Online Comment

Application H05-0444-18
Location HOME FARM TORRINGTON LANE FLEET PE12 8NJ
Proposal Proposed barn conversion to residential dwelling including raising the roof and rear extension

Name Sue Armour
Address Environmental Protection South Holland District Council

I reviewed the Goldfinch Environmental Ltd report ref 'Proposed Residential Development Home Farm Torrington Lane Fleet Hargate Spalding Lincs. Geoenvironmental desk study Report Ref.: 0516/1' dated March 2018.

Site Plan
Scale: 1:250

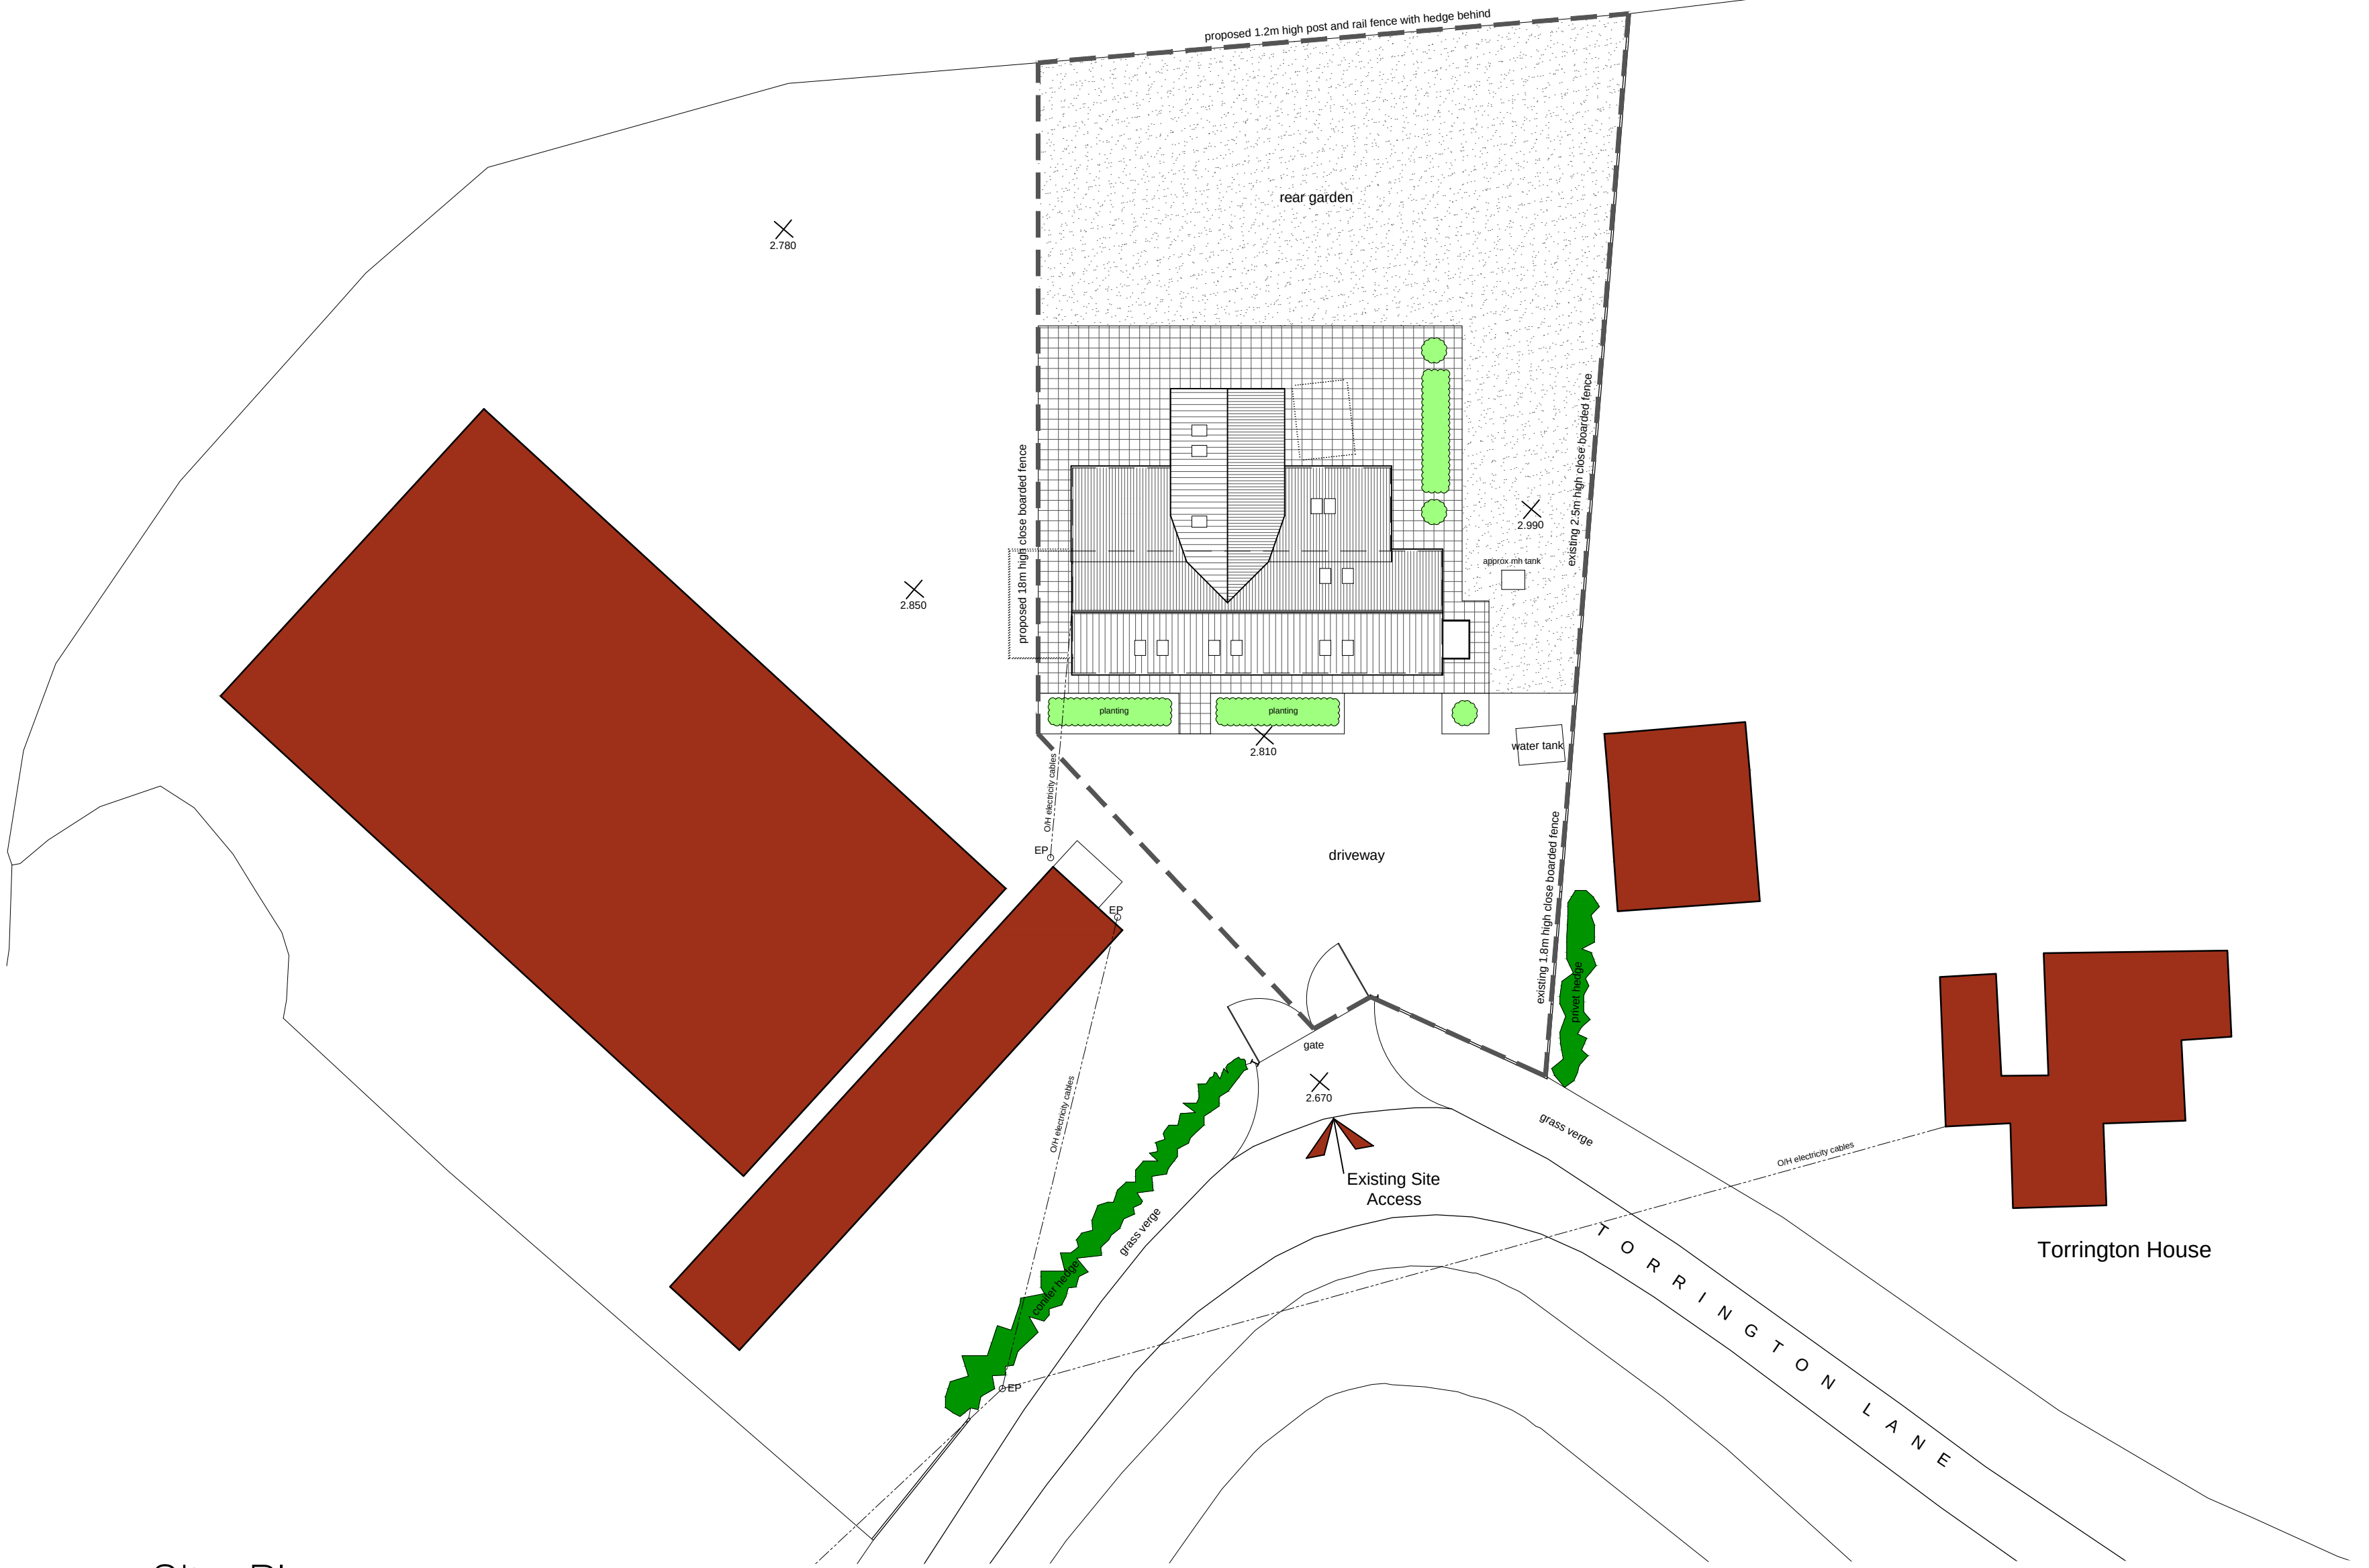
The consultant states that there has been no chemical storage on site, yet their photo dated 2009 on page 6 shows chemical storage tanks. Looking on google maps (which is presumably the source of the photo) the proposed garden to the rear (south west and west) of the building has been used for currently unknown farm storage etc and as such I consider that some further consideration of the suitability of the soils for use in garden areas is warranted.

The development hereby permitted shall not be commenced until a scheme to deal with any contamination of land or pollution of controlled waters has been submitted to and approved in writing by the Local Planning Authority (LPA) and until the measures approved in that scheme have been implemented.
